From: Laura Gibbons <Laura.Gibbons@arun.gov.uk>
Sent: 18 May 2021 15:57
To: Planning.Responses <Planning.Responses@arun.gov.uk>
Cc: Michael Eastham <Michael.Eastham@arun.gov.uk>
Subject: RE: Planning Consultation on: A/84/21/DOC

Thank you for consulting us on this discharge of conditions application, we have the following comments.

Application No:	A/84/21/DOC
Registered:	29th April 2021
Site Address:	Land South of Water Lane Angmering
Description of Works:	Approval of details reserved by condition imposed under ref A/99/17/OUT relating to Condition Nos 23 - maintenance & management of sustainable drainage scheme (SuDs), 24 - foul water sewerage disposal, 25 - discharge flows to watercourses, 26 - future access & maintenance of any watercourse or culvert and 28 - Flood Risk Assessment & surface water drainage strategy.

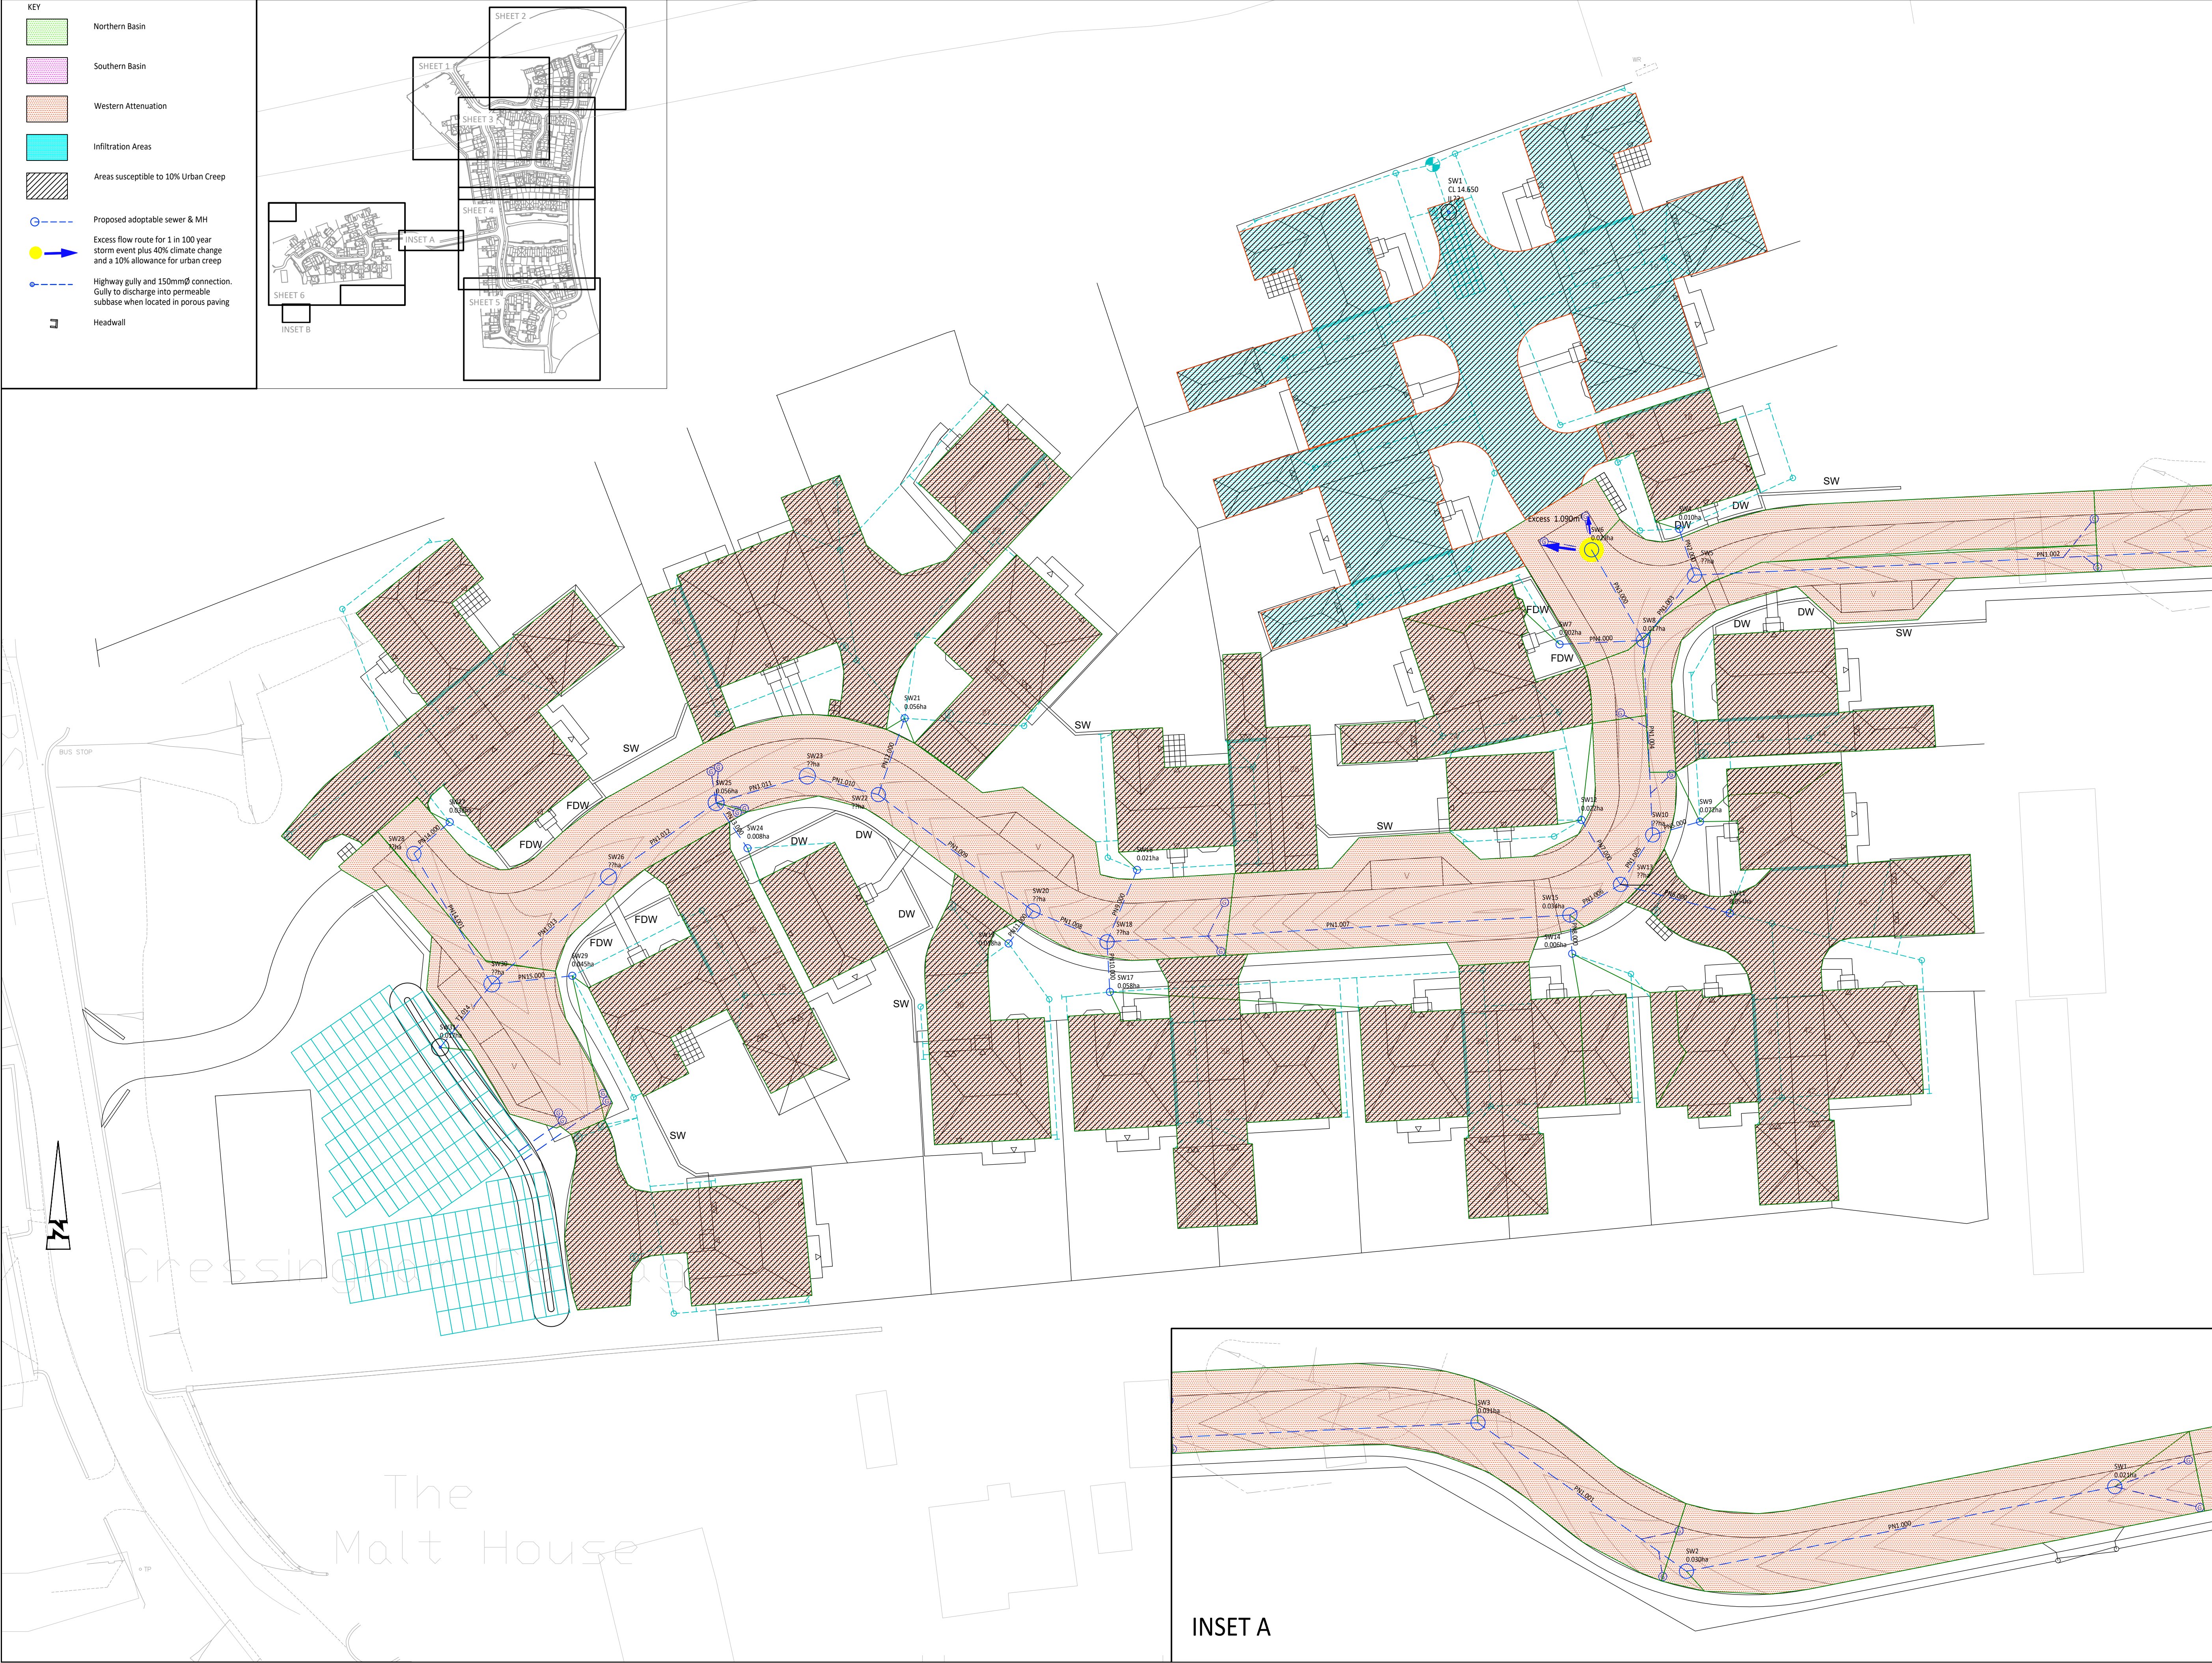
Please make it clear on impermeable areas plans and calculations where urban creep is added. The results provided show impermeable areas plans for the northern catchment matching those in the first set of calculations in the previous printout, which according to your above statement did not include urban creep.

Please make it clear on impermeable areas plans and calculations where urban creep is added.

Figure 2: Proposed detail of access road and culvert, including upstream and downstream step access to watercourse.

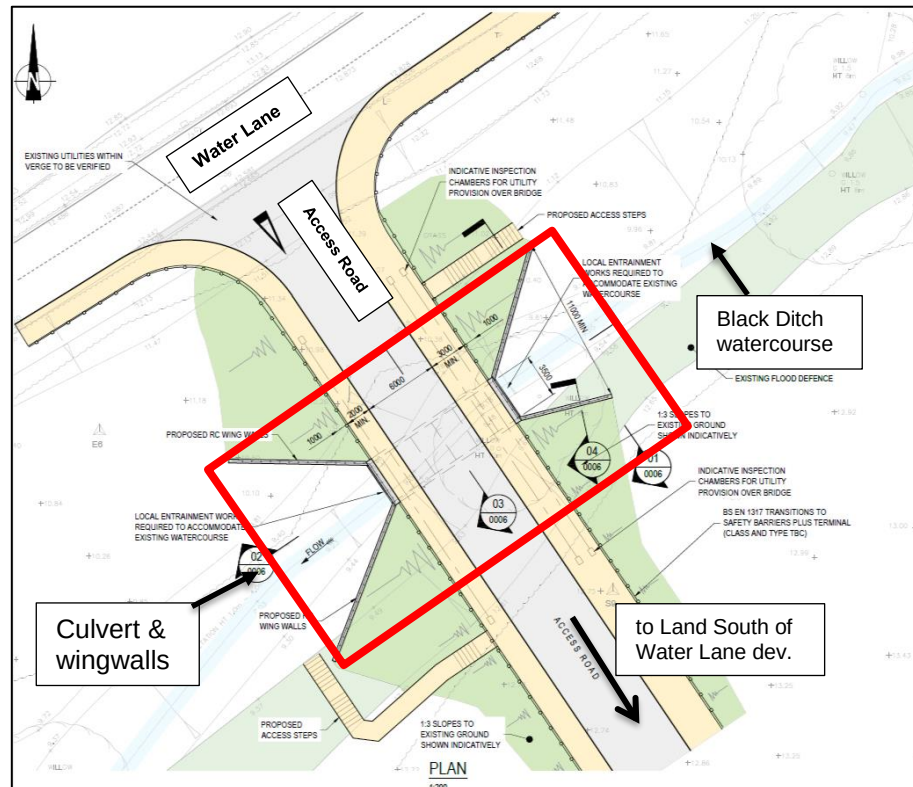
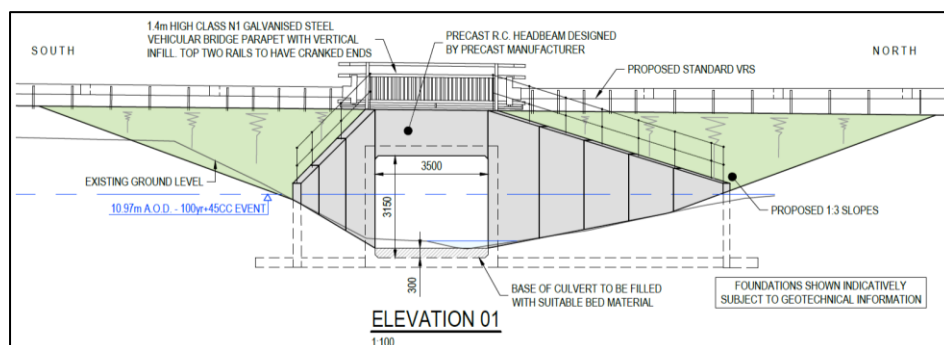
We note that a flood risk activity permit has been provided for the culverting of the watercourse, it does not appear that a consent is in place for discharging water to the watercourse specifically the headwall construction. Please can the applicant provide further details of the proposed headwall, as per the below comments.

This has been noted and included on the drawings. It is still not clear what the construction detail drawing is for the connection to the watercourse. Is it the same as those into the basin, or different? Please clearly define. The watercourse headwall should be a site specific detail which includes bed and bank levels and proposed invert level.

Drainage maintenance Plan

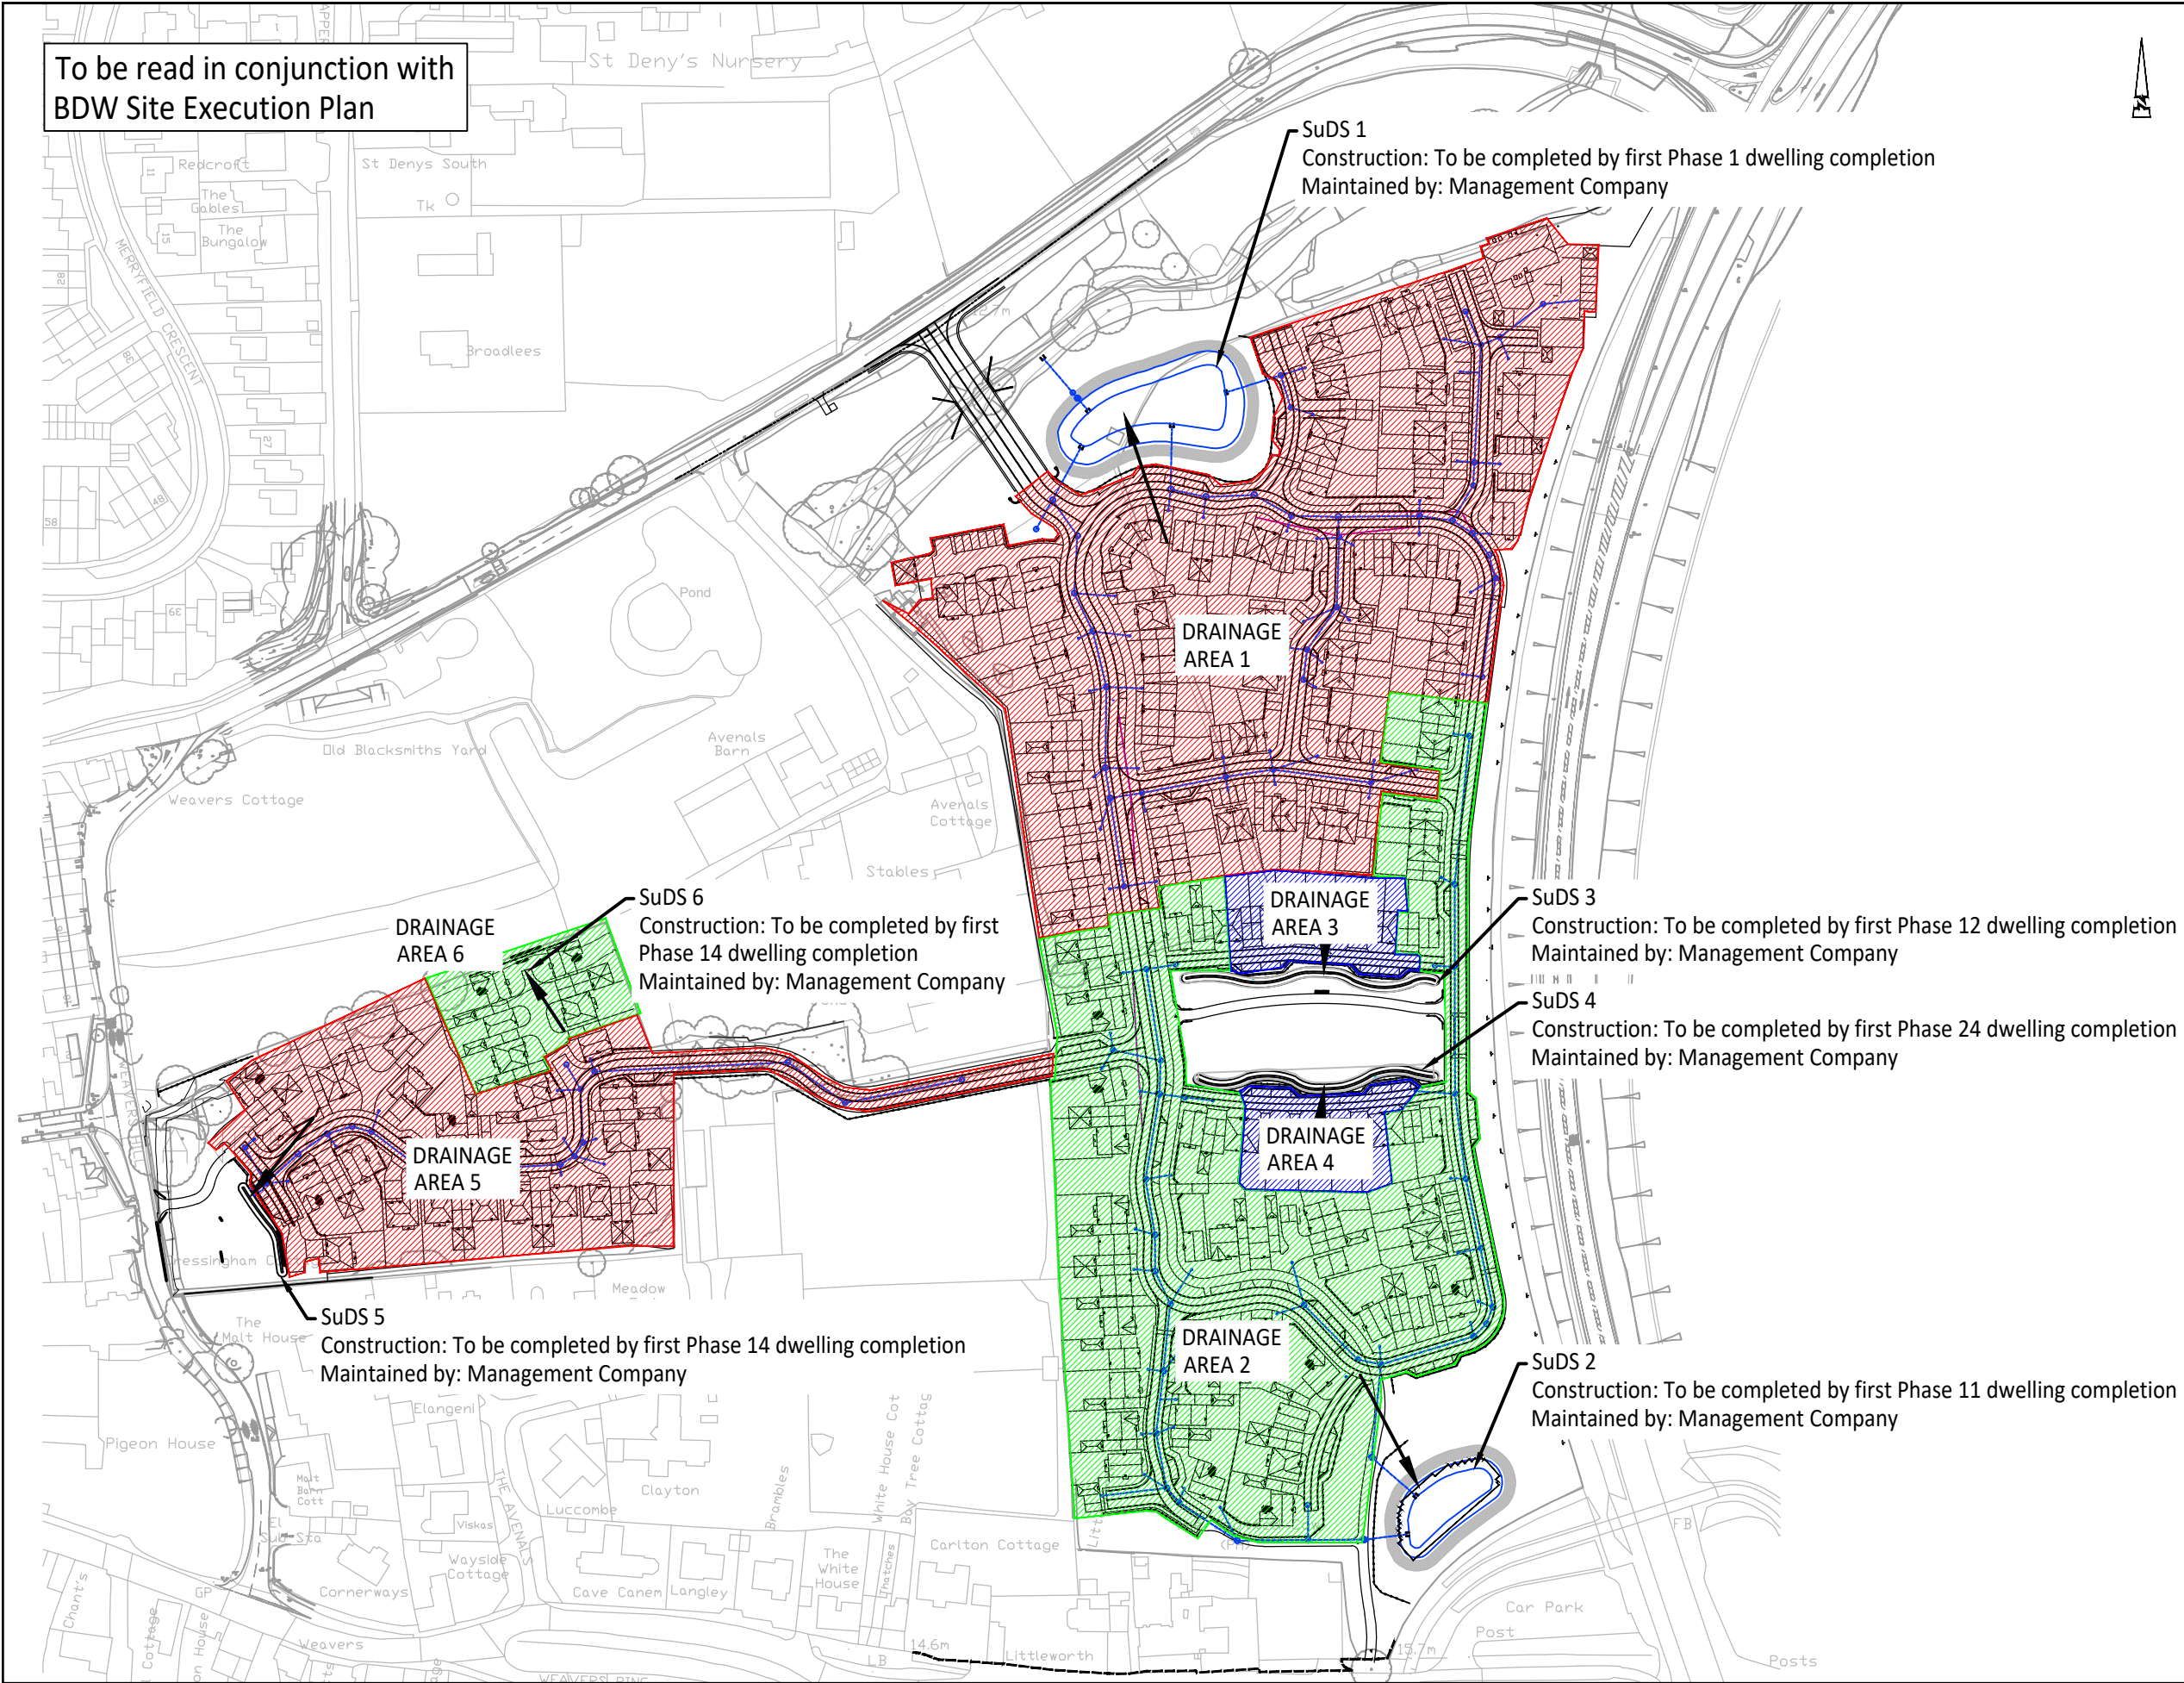
- The maintenance manual must detail how maintenance of the surface water drainage system will be funded and who will undertake this. Design lifetimes of elements must be included along with details of the requirement to replace elements at the end of their lifetime.
